Item No. Report of the Head of Planning, Sport and Green Spaces**Address** 5 DRYSDALE CLOSE NORTHWOOD**Development:** Single storey front extension**LBH Ref Nos:** 30482/APP/2015/458**Drawing Nos:** 14025/61/P0
14025/00/P1
140205-60-P3**Date Plans Received:** 06/02/2015 **Date(s) of Amendment(s):** 06/02/2015**Date Application Valid:** 24/04/2015 11/02/2015**1. CONSIDERATIONS****1.1 Site and Locality**

The application seeks planning permission for the erection of a single storey front extension.

140205-60-P3

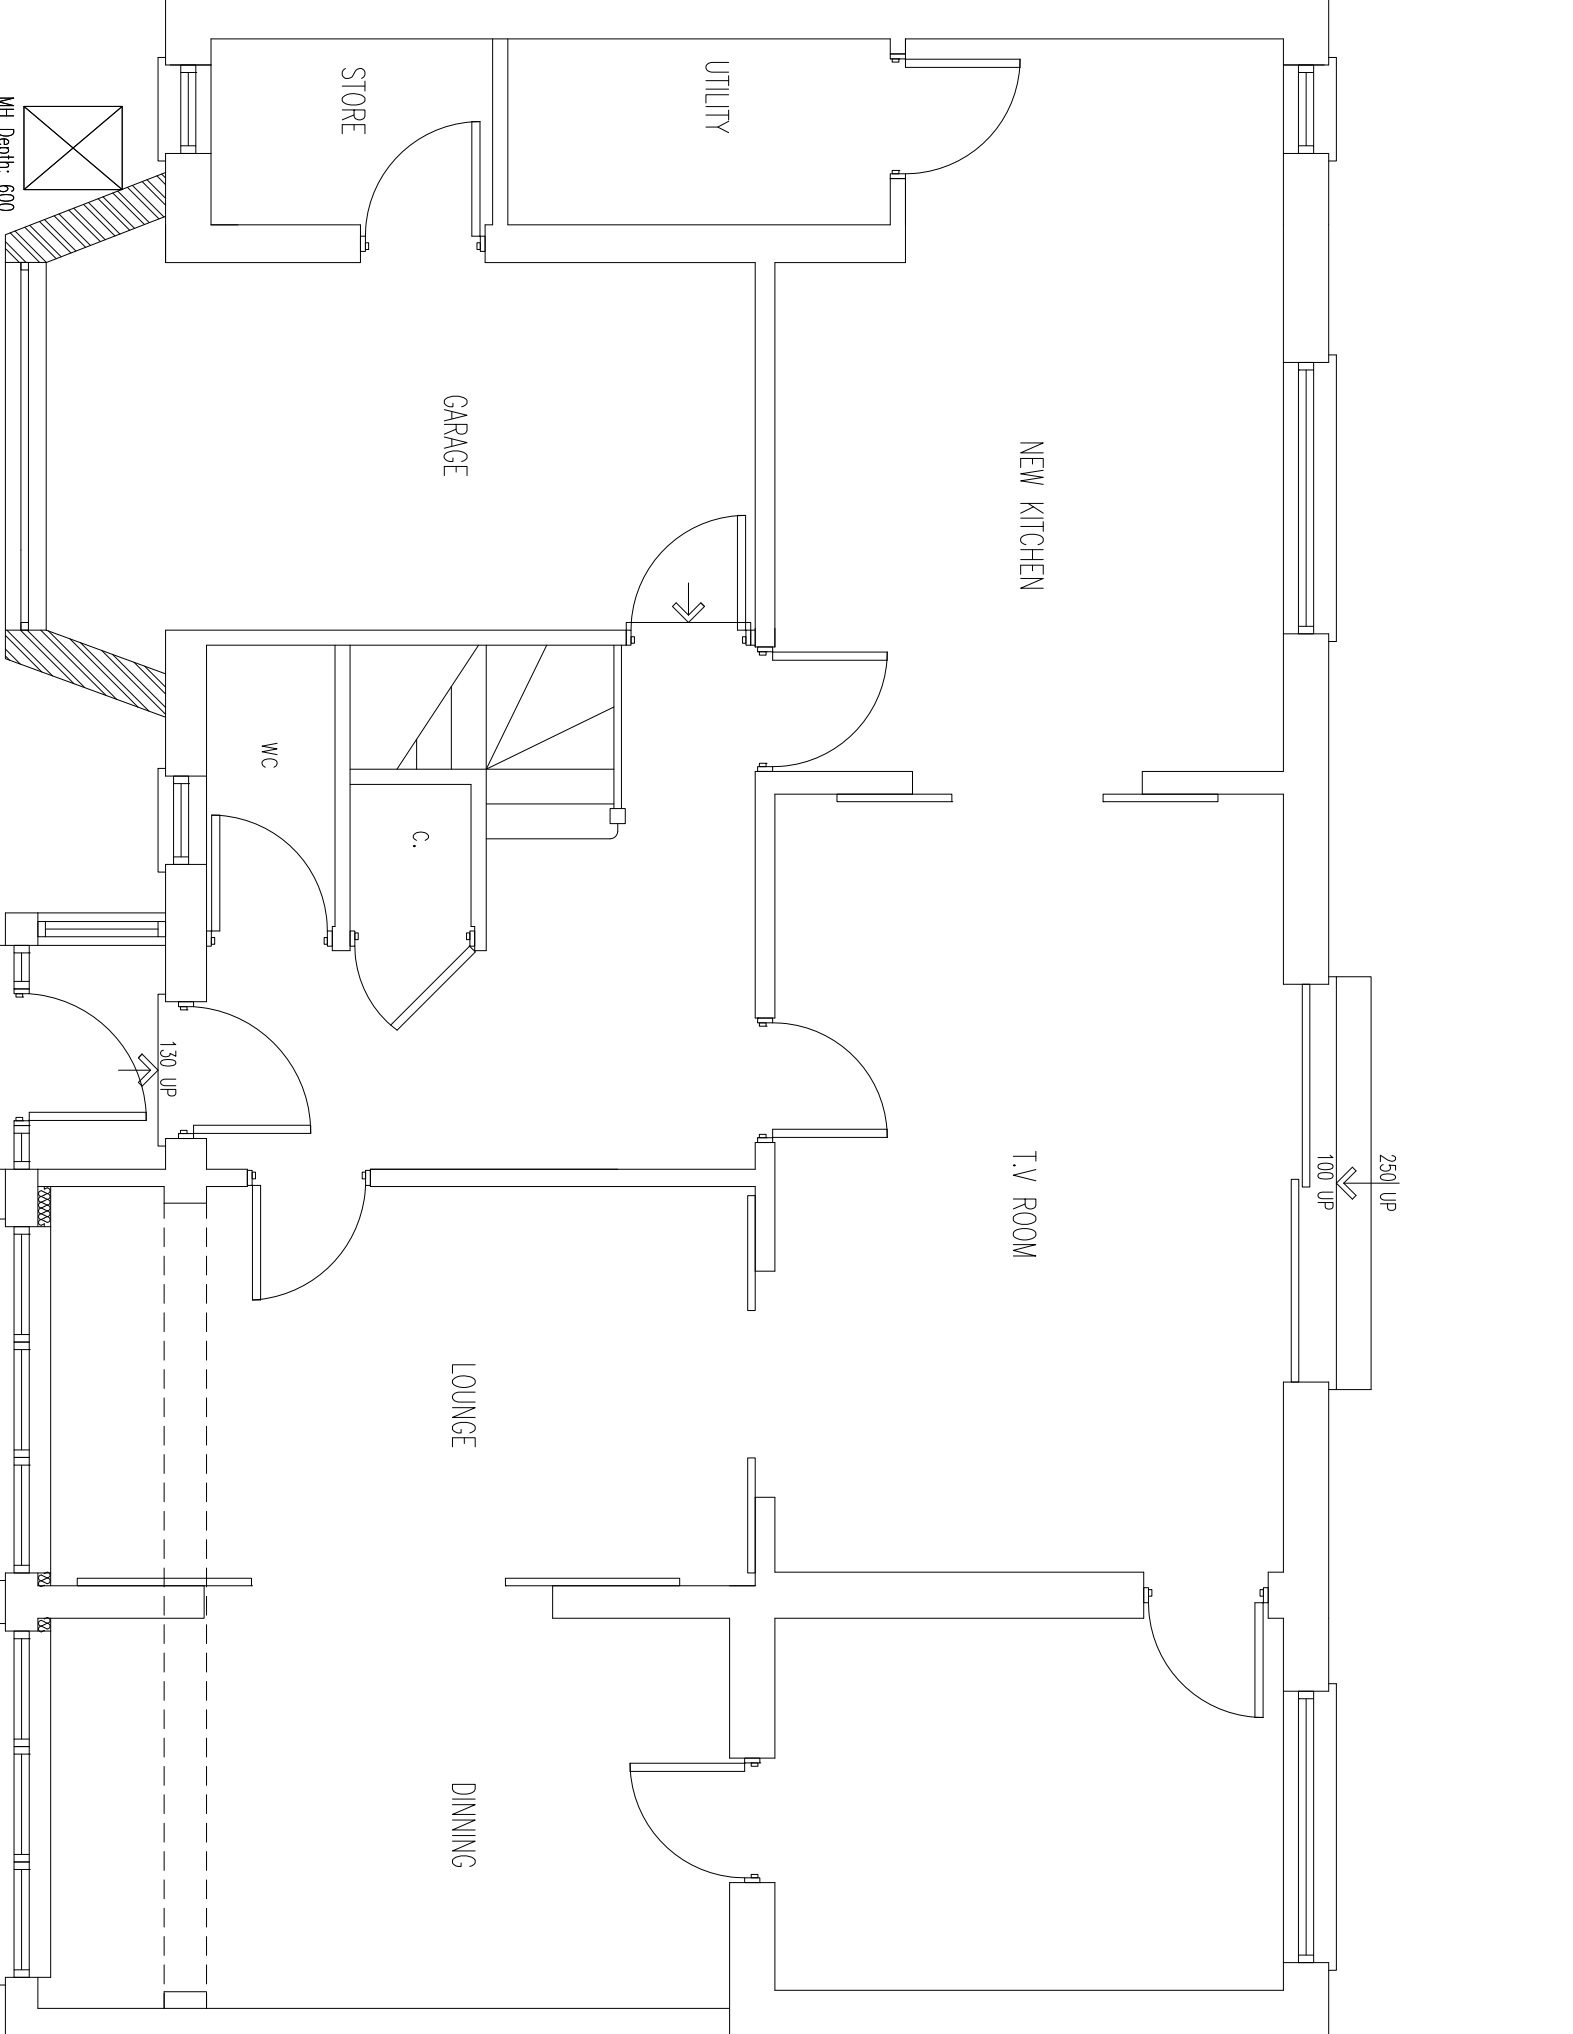
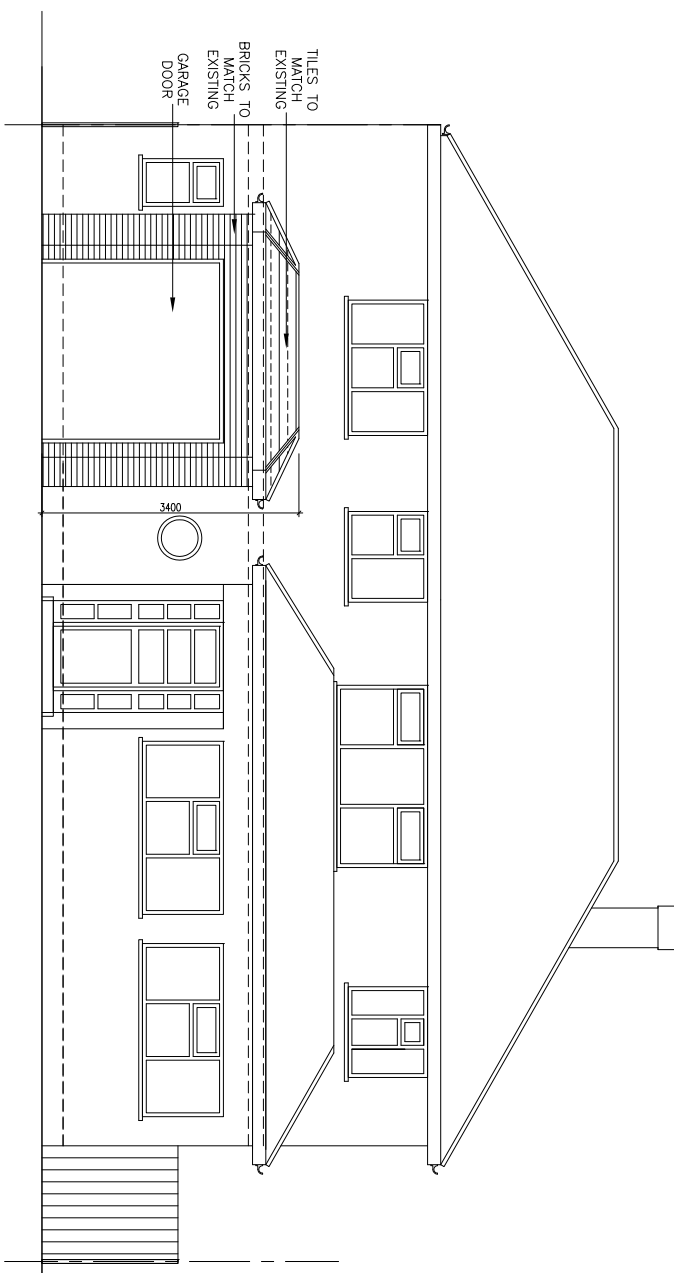
The proposed front extension would extend forward from the main dwelling house by 2 metres, bringing it in-line with the existing front extension of the property. The height of the proposed extension is 3.4 metres, which is 0.50m lower than the height of the existing front extensions. Plans show that there is a 1.3m distance from the proposed extension and the existing front extension, however this separation does not eliminate the fact that the proposal creates a perception of the property having one large front extension. This is something that the Council does not approve of, as it will have a negative impact upon the character and style of the street scene. The other properties on the same side as the application property, all have part front extensions same as the application property currently has. As a result, the front extension is considered to form an disproportionate addition that would have a significant impact on the character of the original property and the visual amenity of the surrounding area. Therefore, the proposed development is not in accordance with Policies BE13, BE15 and BE19 of the Hillingdon Local Plan: Part Two - Saved UDP Policies (November 2012).

The proposed front extension, by virtue of its position, size, scale and design, would result in an incongruous and overly dominant addition which would be detrimental to the architectural composition of the existing building and the visual amenity of the street scene and to the character and appearance of the wider area. The proposal would therefore be contrary to Policy BE1 of the Hillingdon Local Plan: Part One - Strategic Policies (November 2012), Policies BE13, BE15 and BE19 of the Hillingdon Local Plan: Part Two - Saved UDP Policies (November 2012) and the adopted Supplementary Planning Documents HDAS: Residential Extensions.
